WEST SUSSEX COUNTY COUNCIL CONSULTATION

TO:	Arun District Council FAO: Hannah Kersley
FROM:	WSCC – Highway Authority
DATE:	6 October 2026
LOCATION:	Hampton Park Littlehampton
SUBJECT:	LU/252/25/RES Approval of reserve matters following LU/47/11/ (as amended by LU/182/15/) for the remaining open space elements including playing pitches, changing rooms, car parking area, northern allotments and the eastern extent of the Black Ditch Open Space. Substitute and Supplementary drawing pack plans received.
DATE OF SITE VISIT:	n/a (desktop study undertaken for purposes of this planning application)
RECOMMENDATION:	More Information Required

This is the **second** WSCC Highways response to the above planning application seeking approval of reserved matters following LU/47/11/ (as amended by LU/182/15/) for the remaining open space elements including playing pitches, changing rooms, car parking area, northern allotments and the eastern extent of the Black Ditch Open Space.

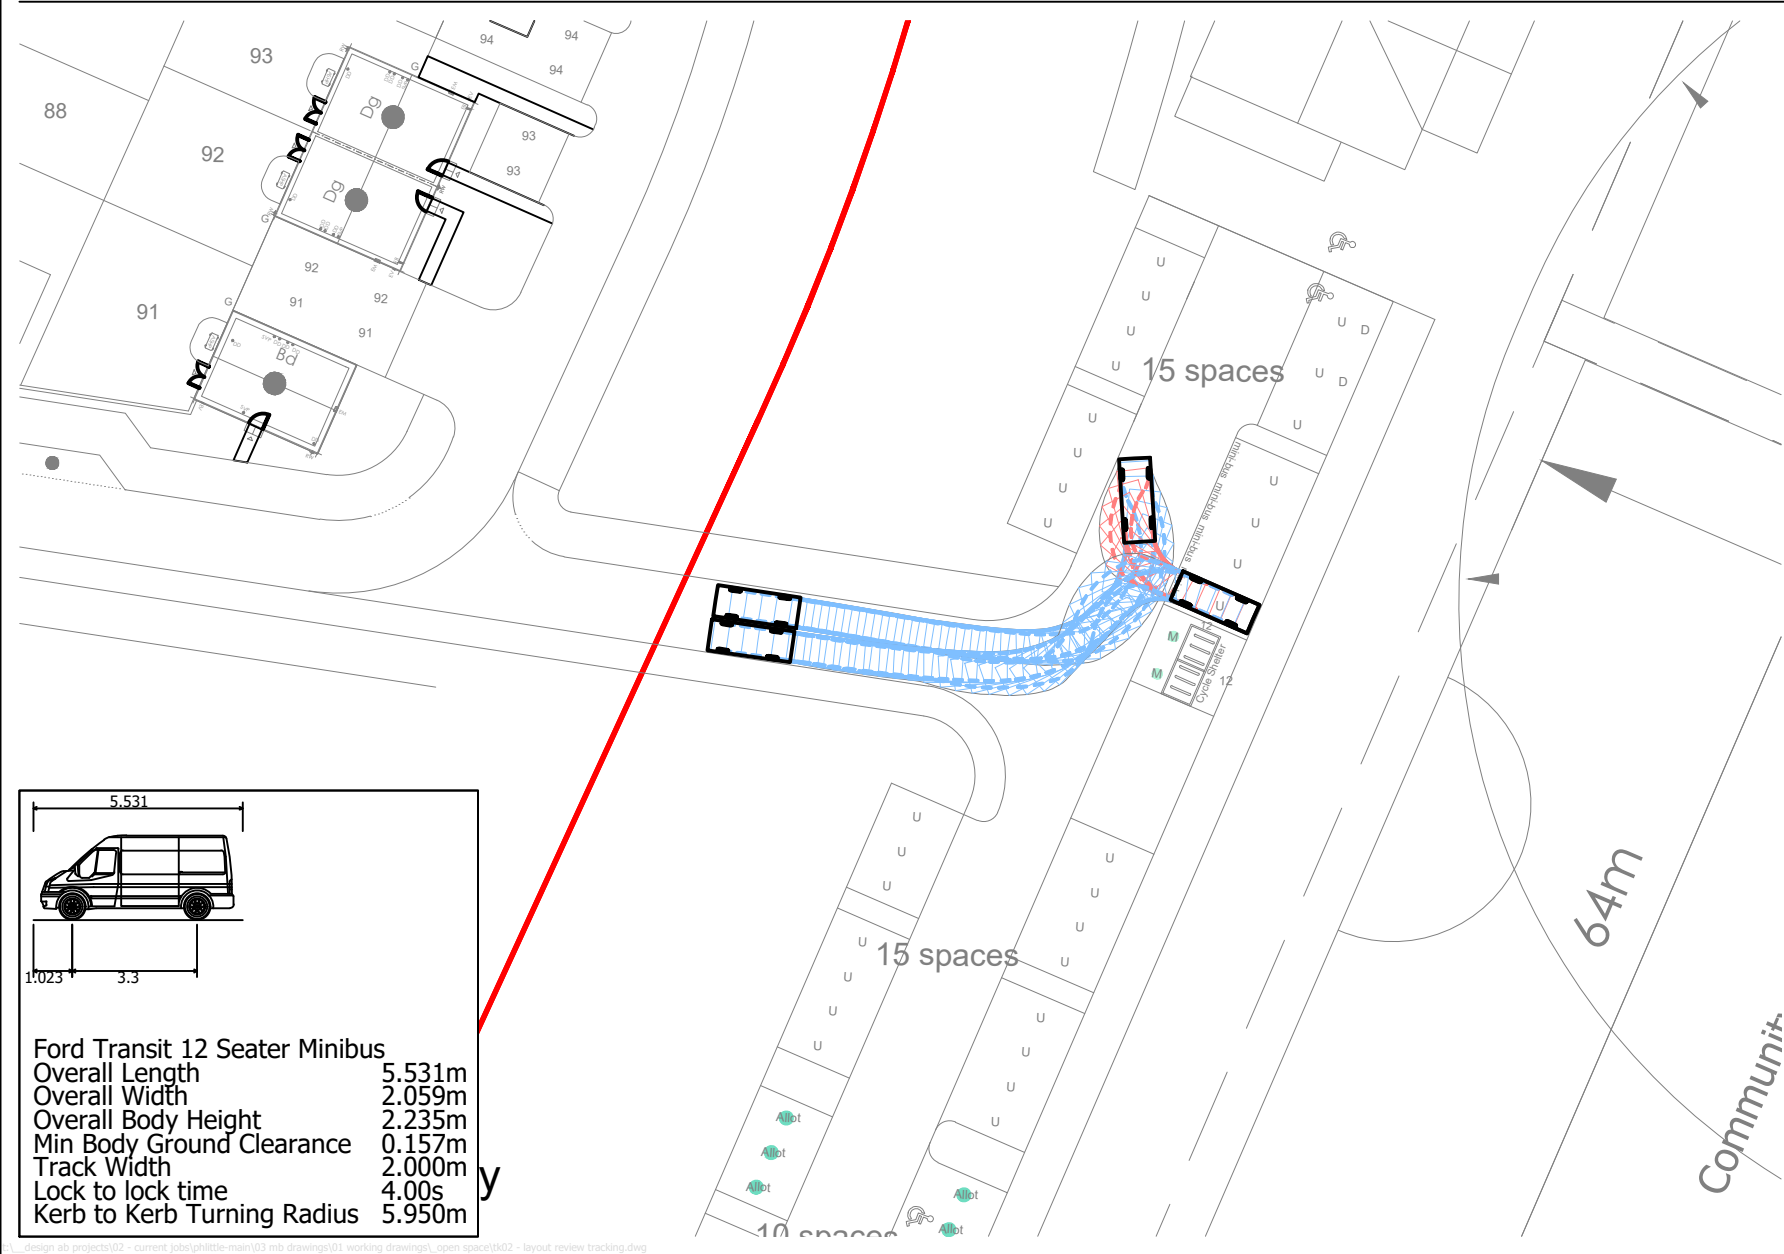
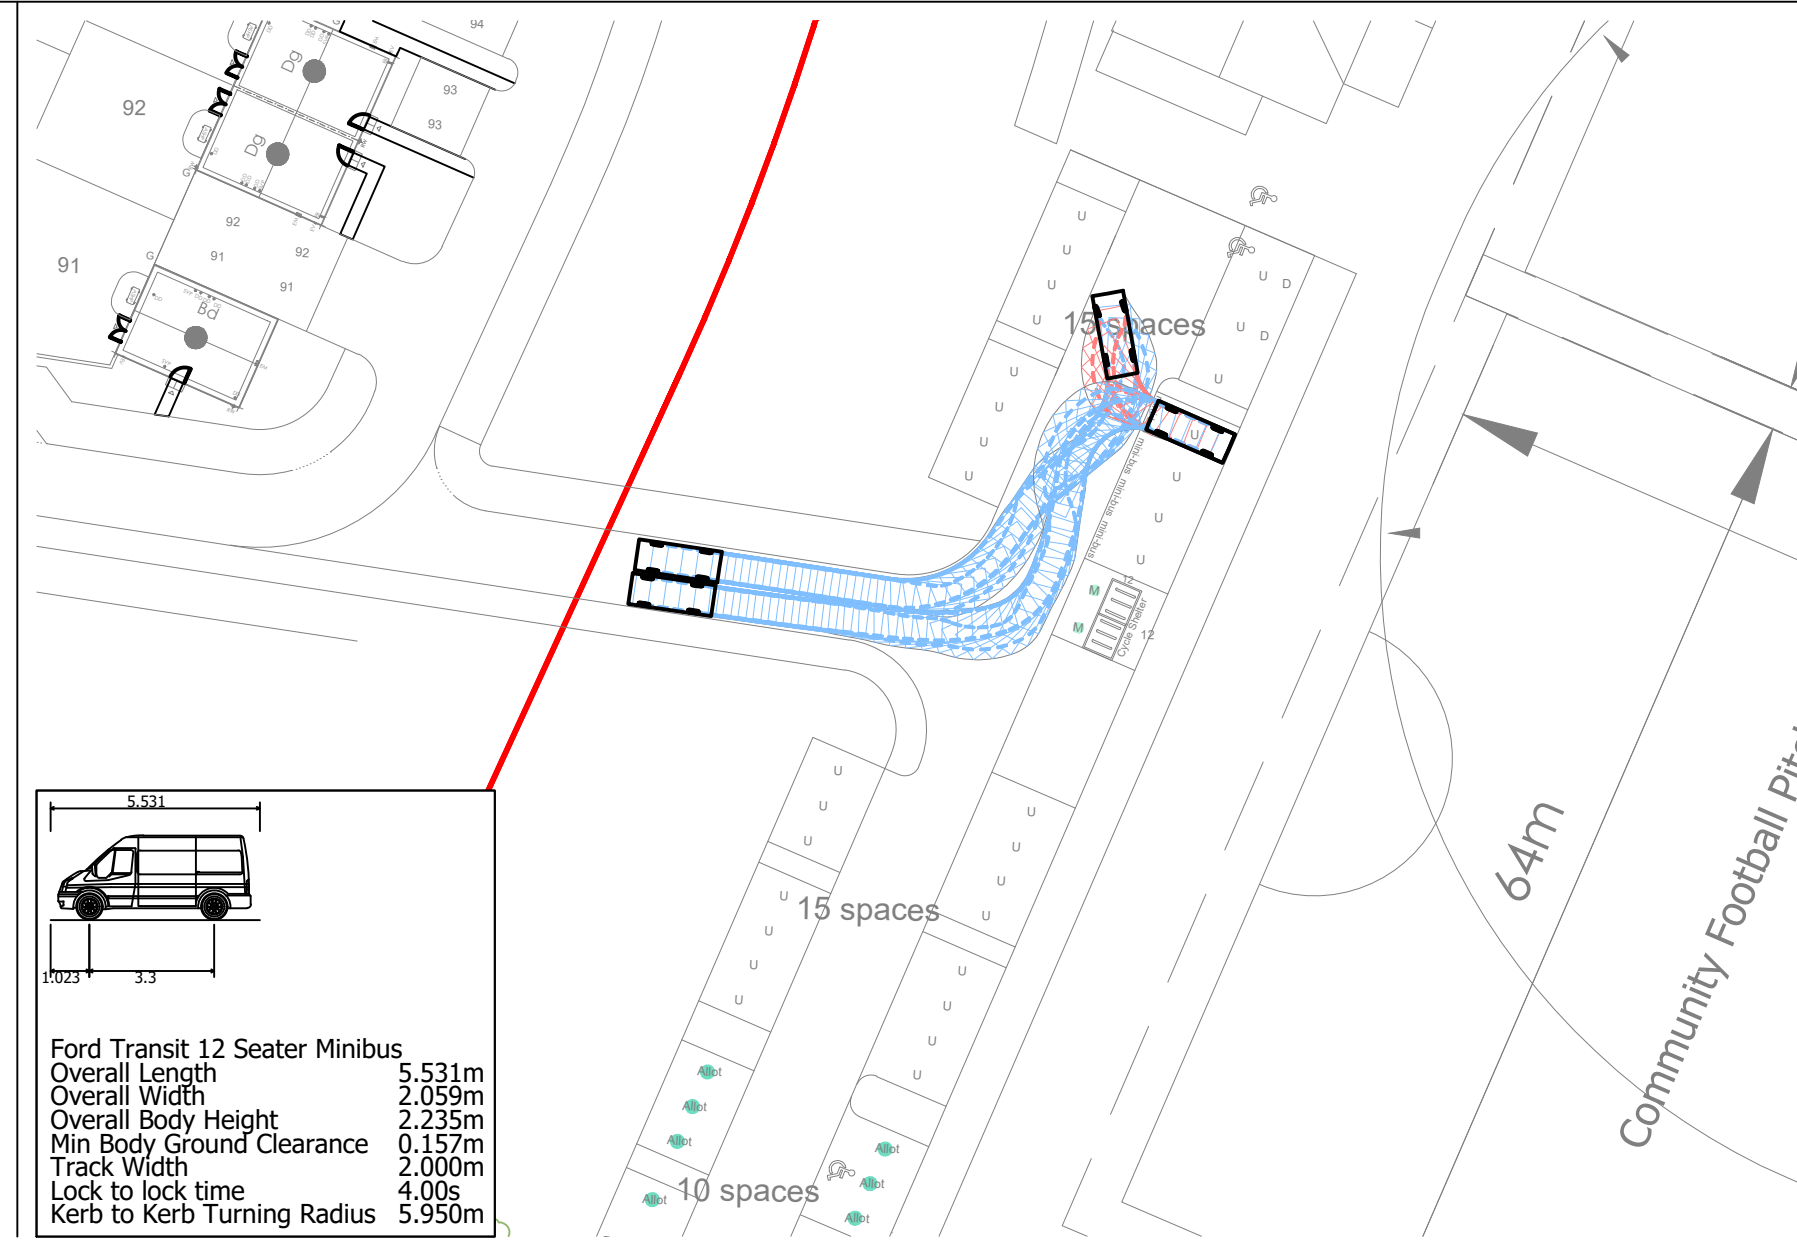
- A plan showing provision for a coach (plus swept path analysis of the same).
This is now shown on Drawing PHLITTLEOS.2/TK02 Rev 'P1' – 'SWEPT PATH ANALYSIS COACHES IN PAVILION AREA' and also shows the swept path diagrams for a light van.
